**FINAL DRAINAGE REPORT
FOR
STIMPLE SUBDIVISION
FILING NO. 1**

CCES Responses

PCD Project No. SF-24XX

STIMPLE SUBDIVISION FILING NO. 1
FINAL DRAINAGE REPORT
DEVELOPED DRAINAGE MAP

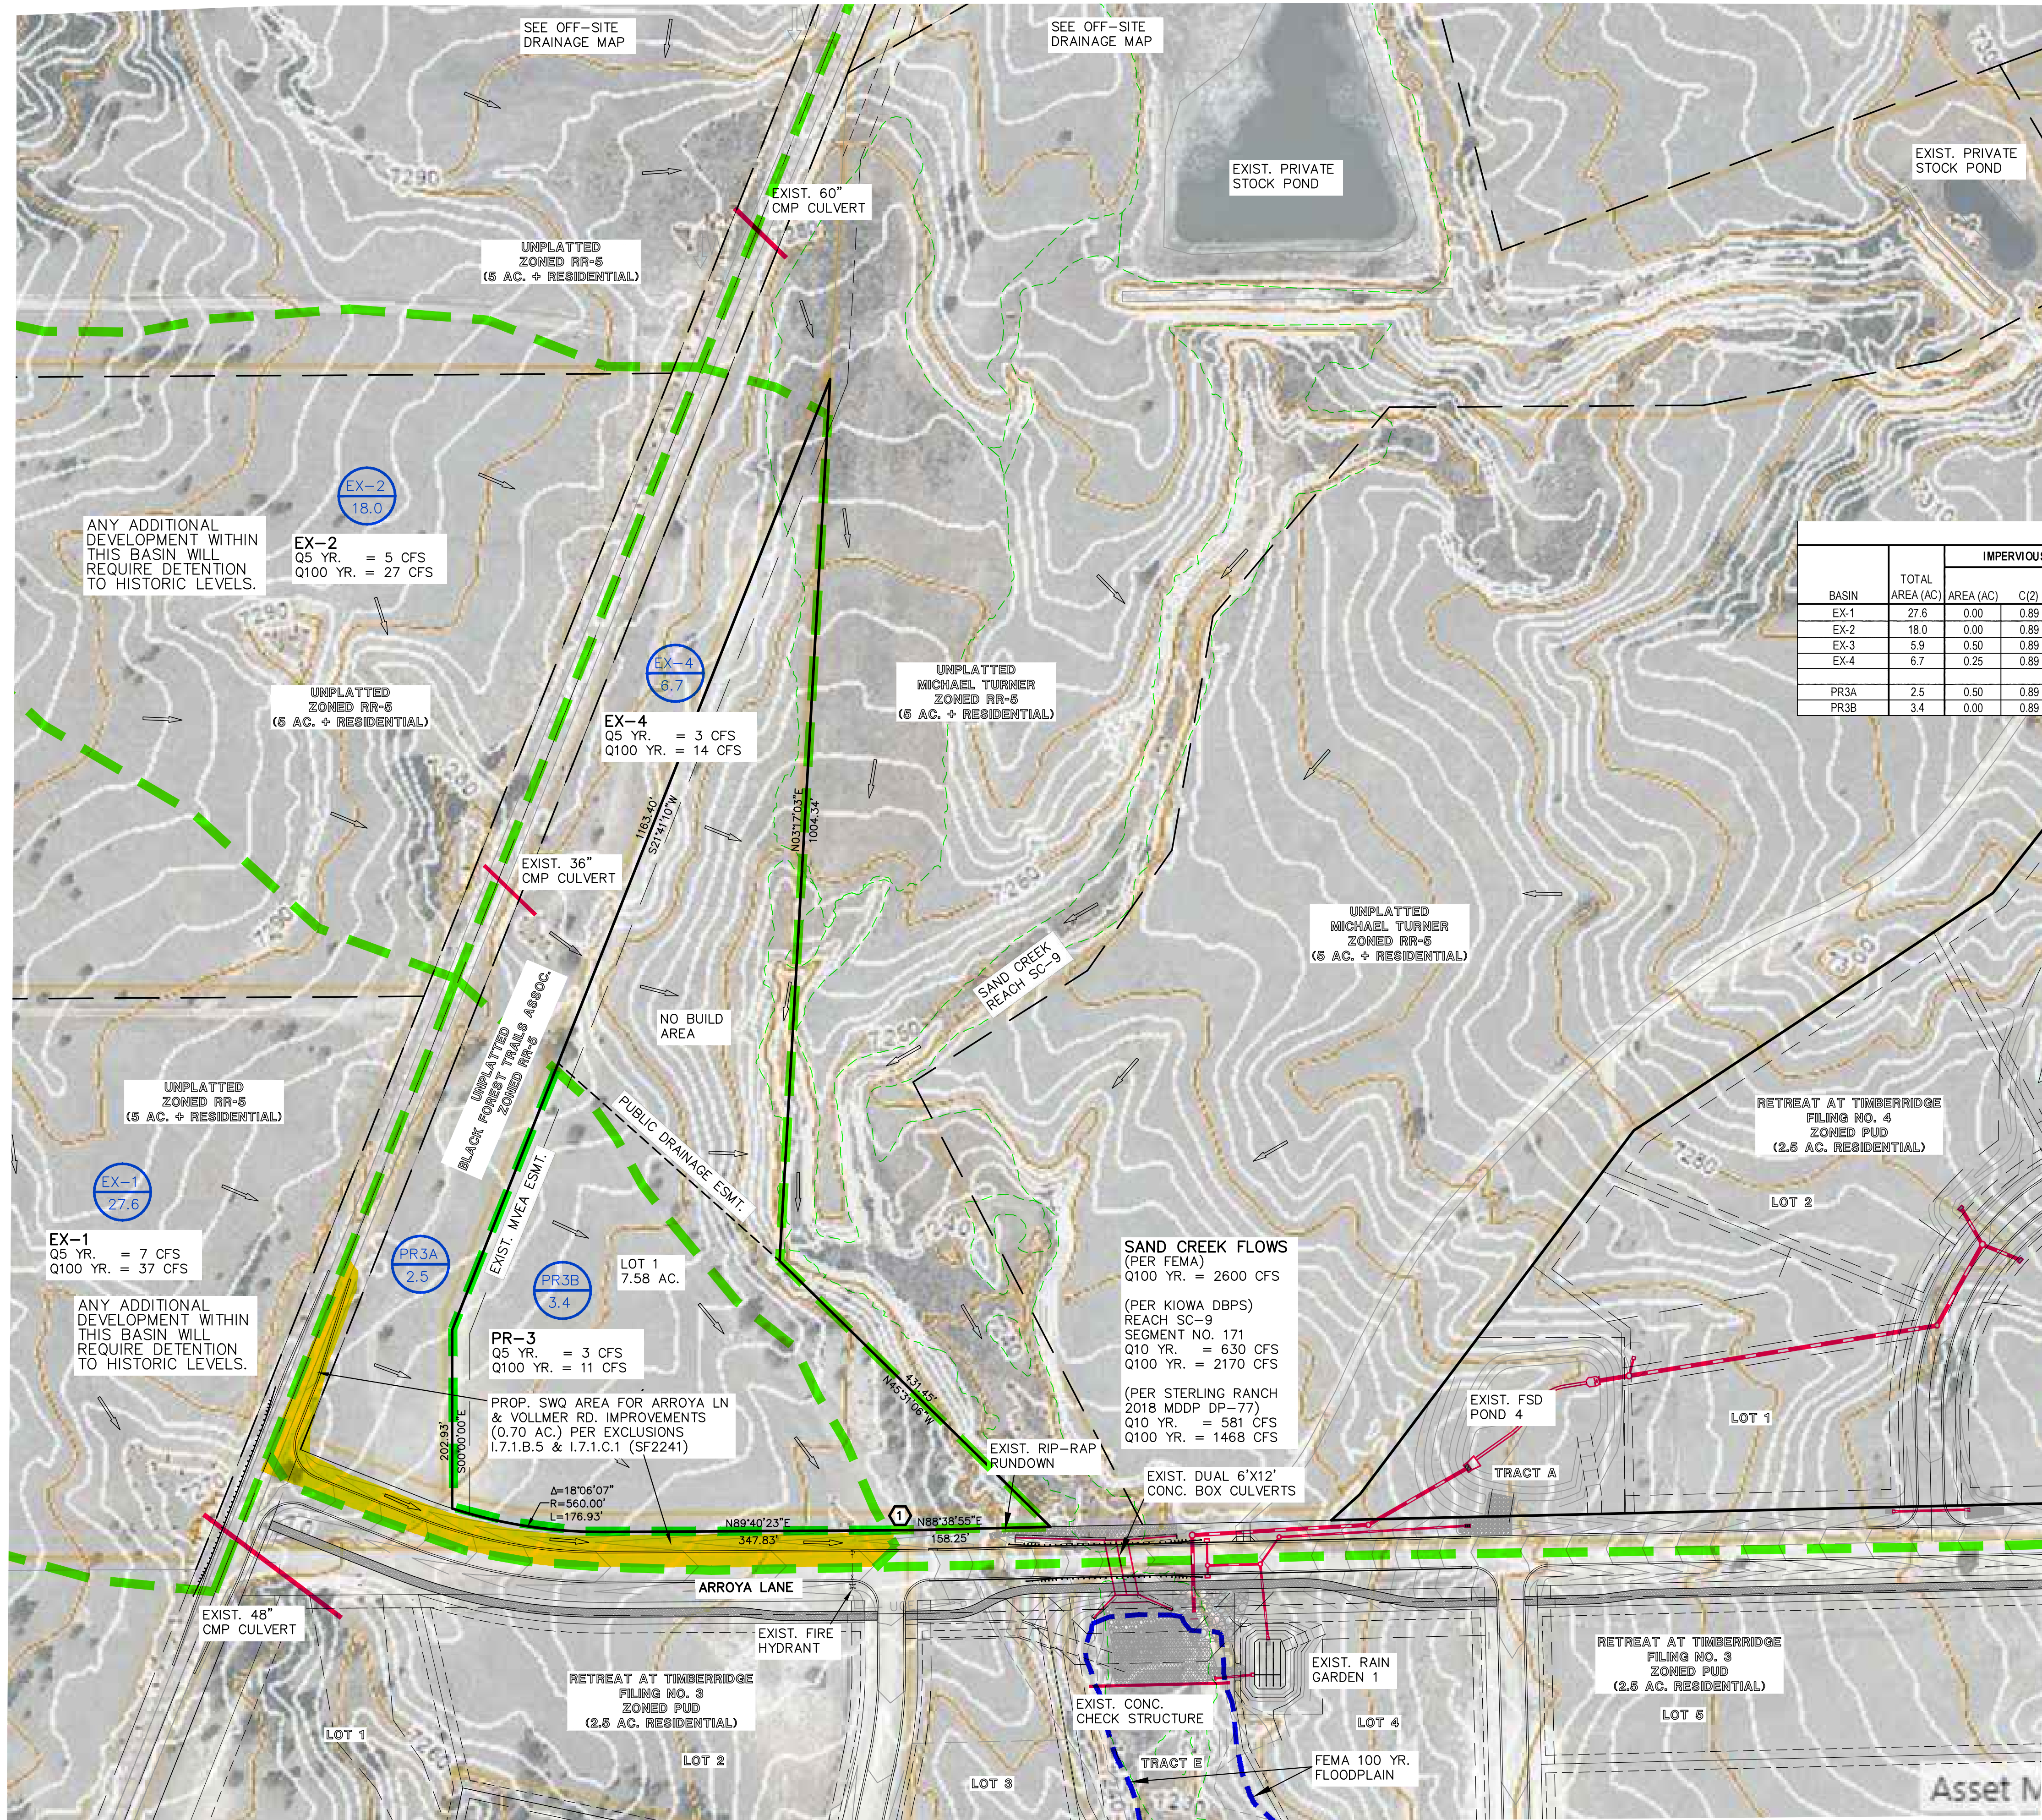
Include statement about TR 3 stating future rain garden would be provided but based upon what is being proposed now, it is no longer needed.

Add a statement indicating that flows at this design point are the same as in TR 3 report and run-down will function adequately/as-designed.

See above comments, the impervious restrictions need to be discussed to apply I.7.1.B.5

This is a 7.5 ac. lot with only one home proposed. The lot itself is under the 10% imp. The reason Basin PR-3 has an imp. % greater than 10% is due to the adjacent Vollmer and Arroya Lane roadways. We have now adjusted the basins to show how the lot itself with a single unit is less than 10% imp. See revised calcs.

See revised basin calcs.

Added

Added

See revised basin calcs.
